<b>Ask for:</b>	Erika Davies
Telephone:	01832 742207
Planning Services	01832 742056
Our Ref:	NE/21/00751/FUL
Your Ref:	PP-09782001
Date:	13 May 2021

**Proposal :**     **Alterations and repairs to outbuildings at Mill Farm House Mill Lane Wadenhoe Northamptonshire PE8 5XD .**

scale 1:50 1:100 @ A1
 date 22.03.21. drawing no. 20.10/01

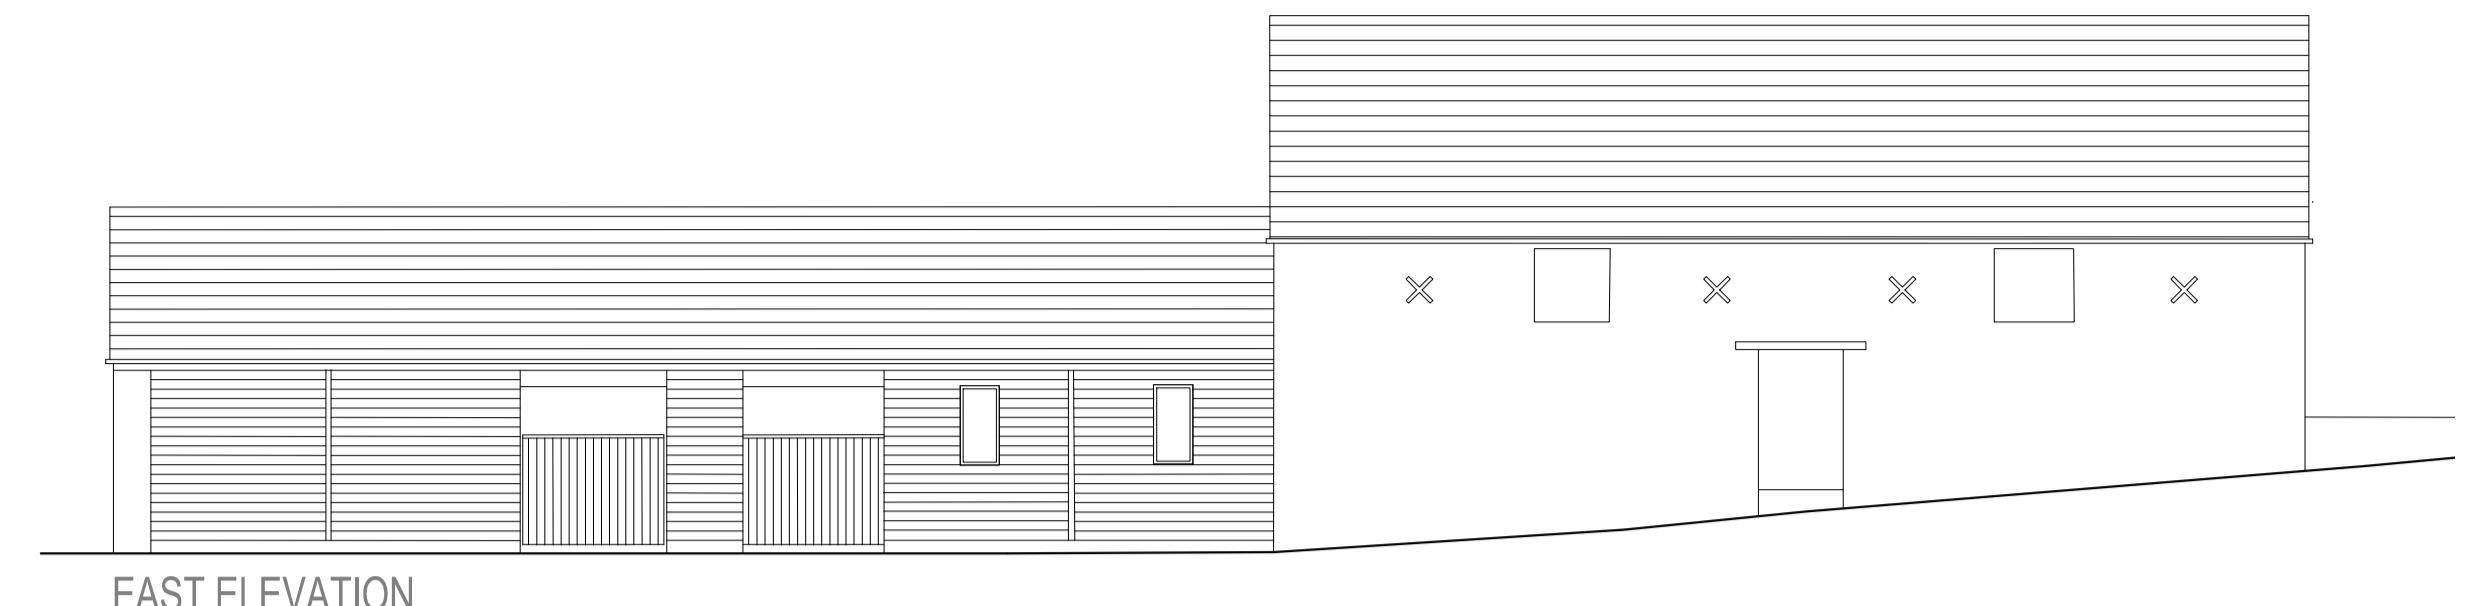
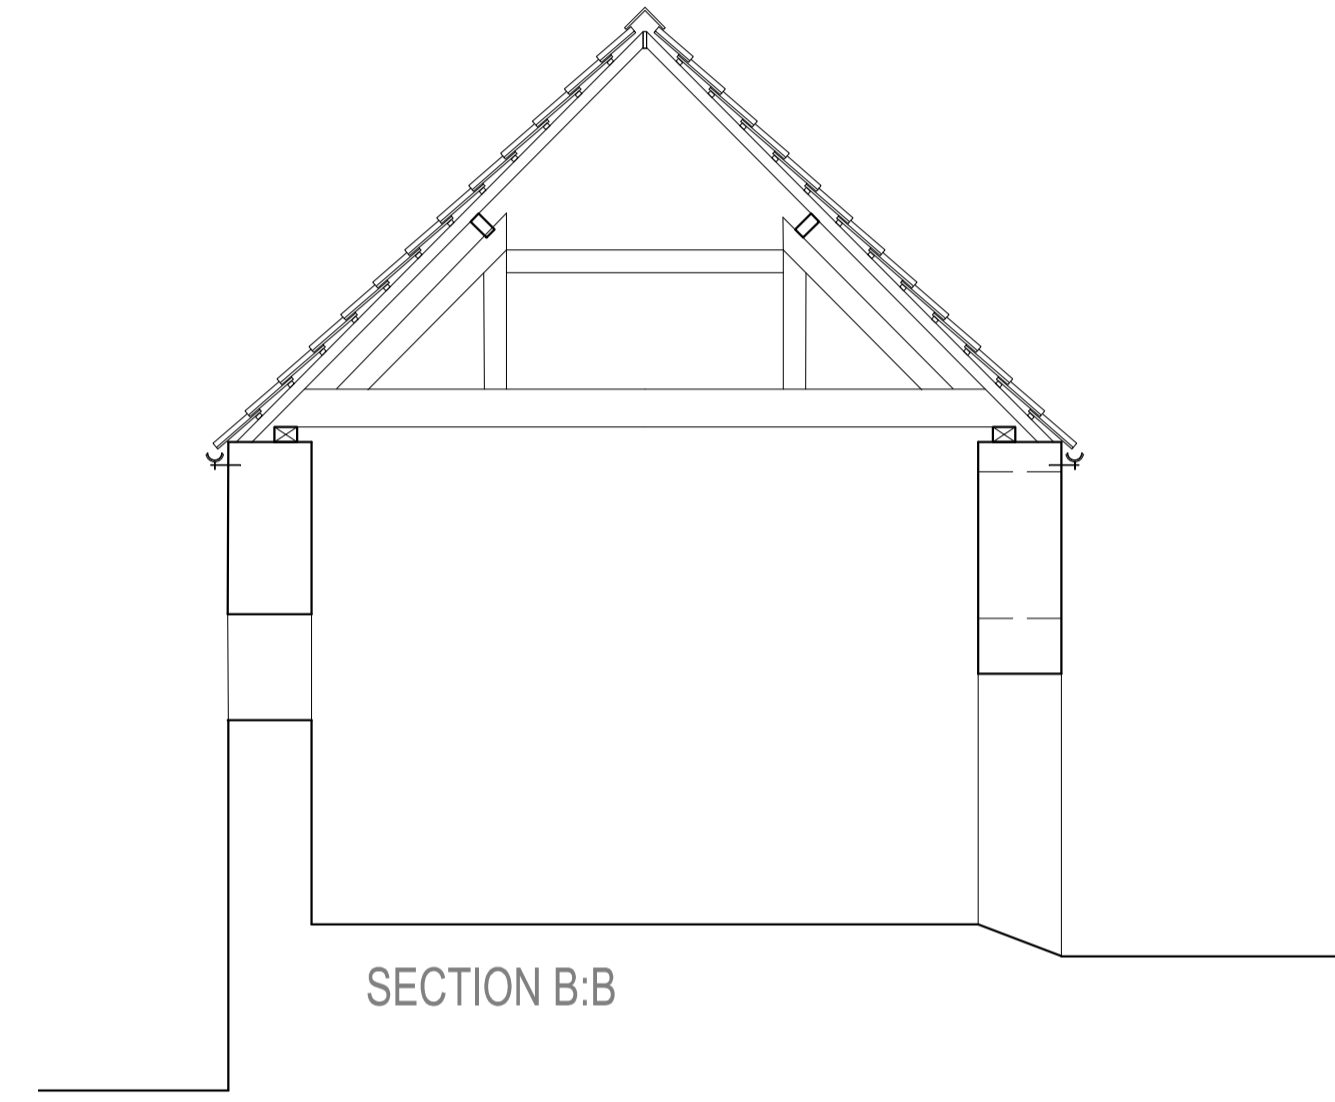
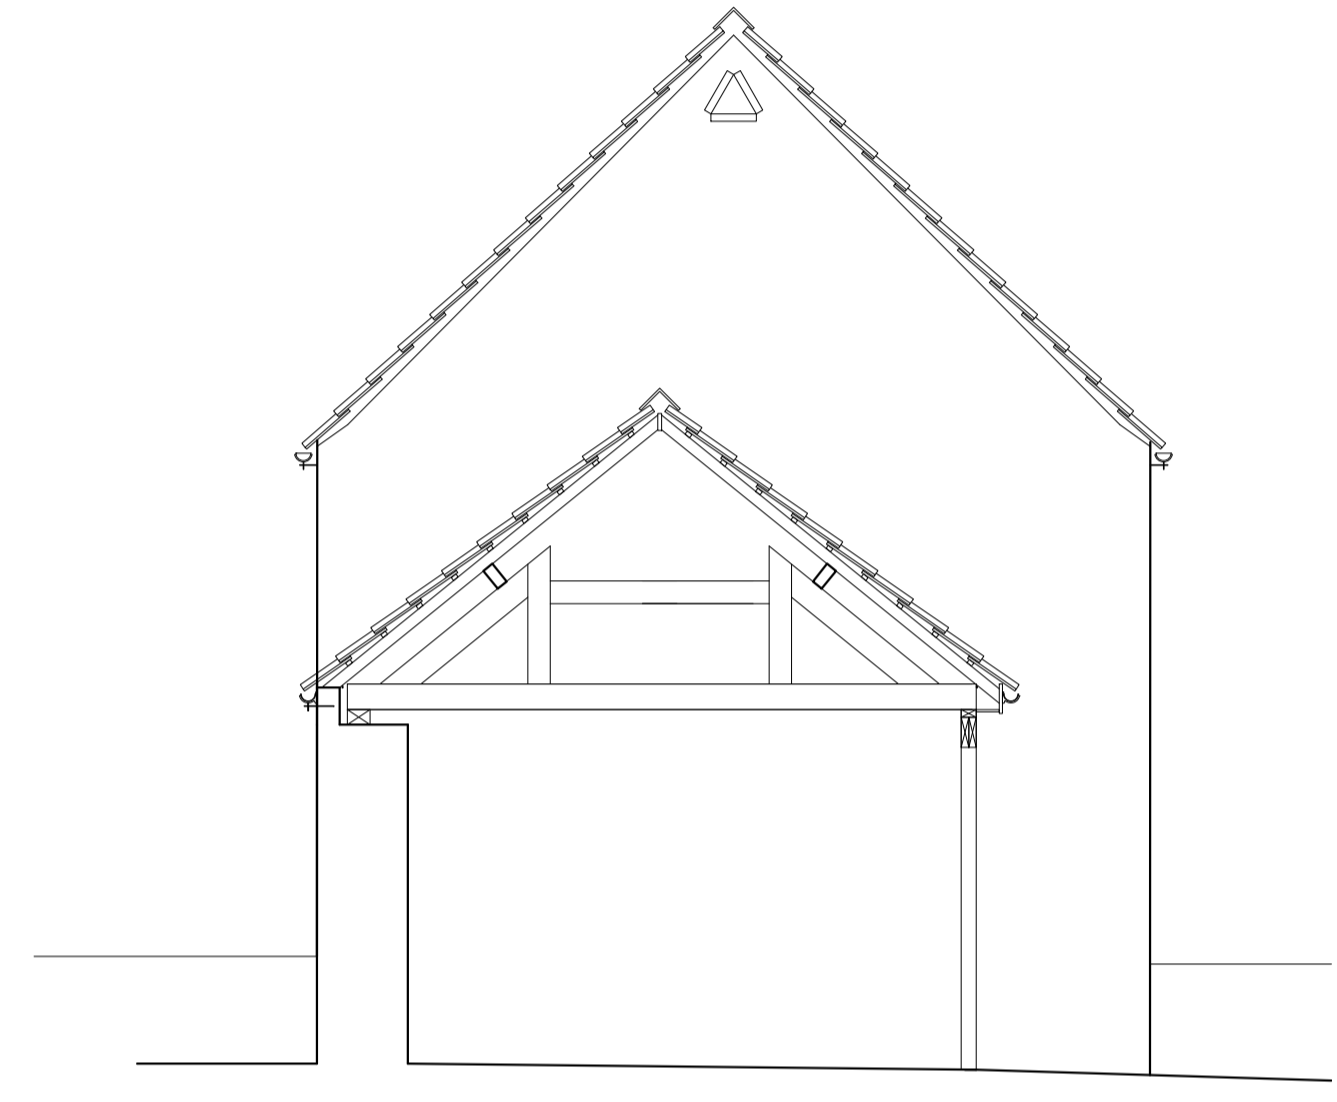
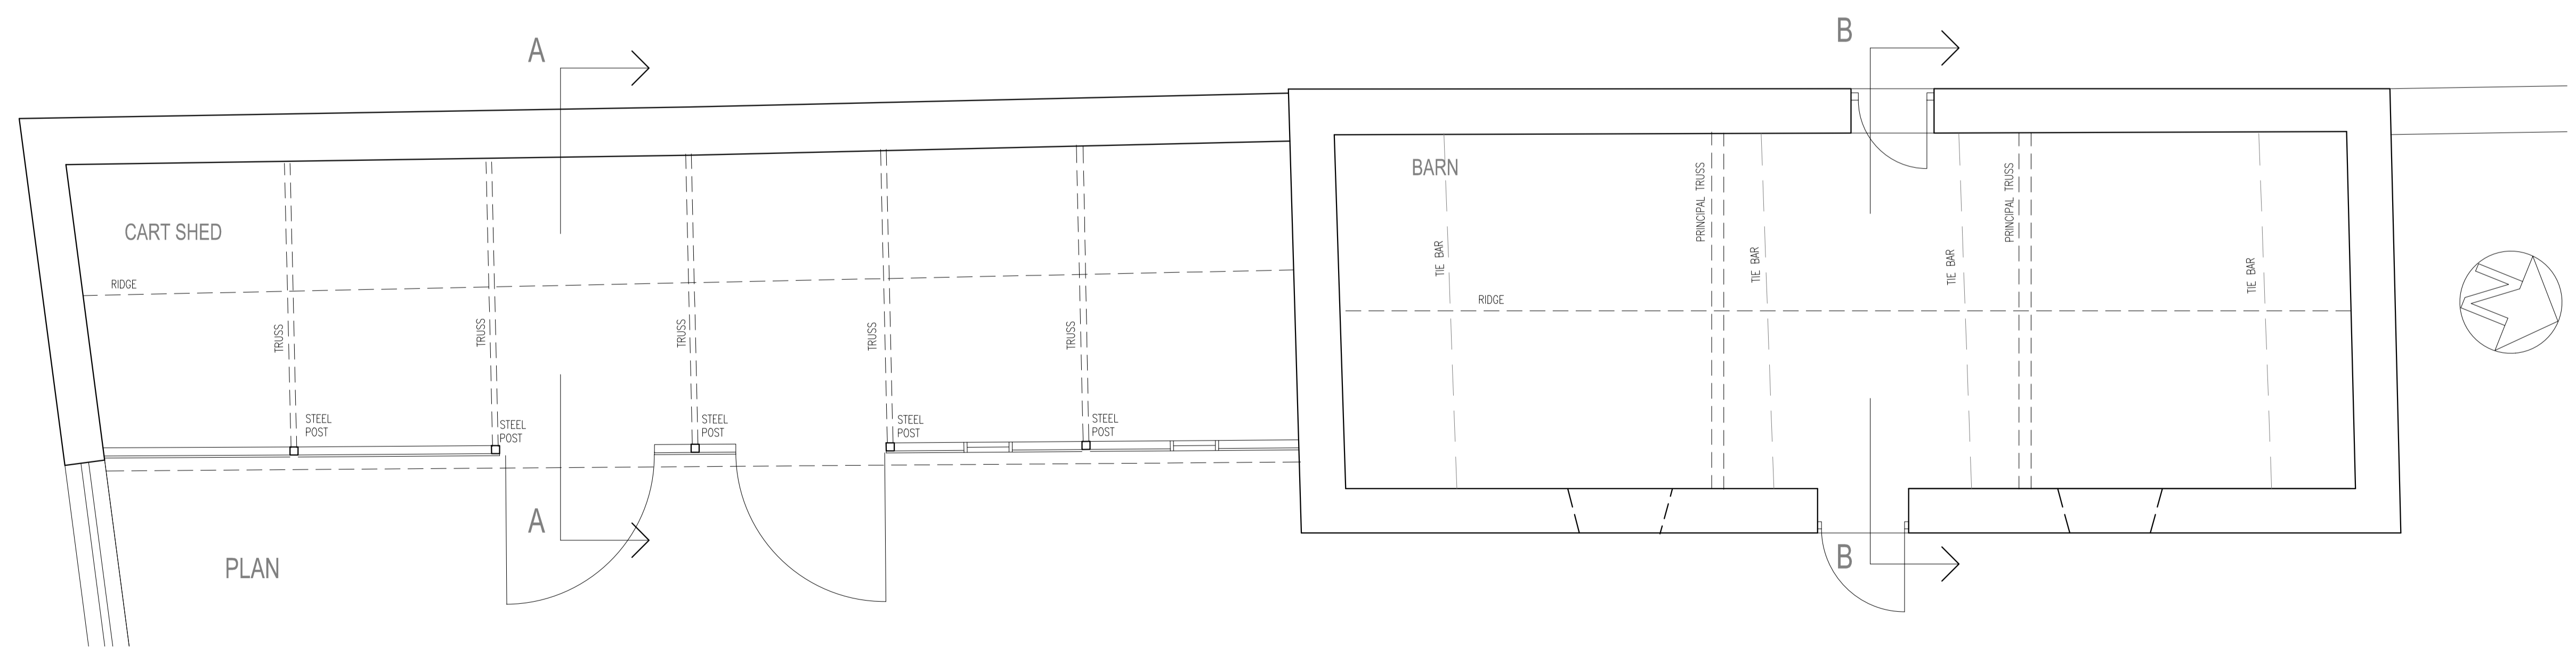
Please provide amended drawings including all relevant dimensions of the proposal:

- Floor plan dimensions
- Dimensions for the existing and proposed elevations annotated with all height dimensions

This will allow the officer to assess any potential visual impact of the scheme.
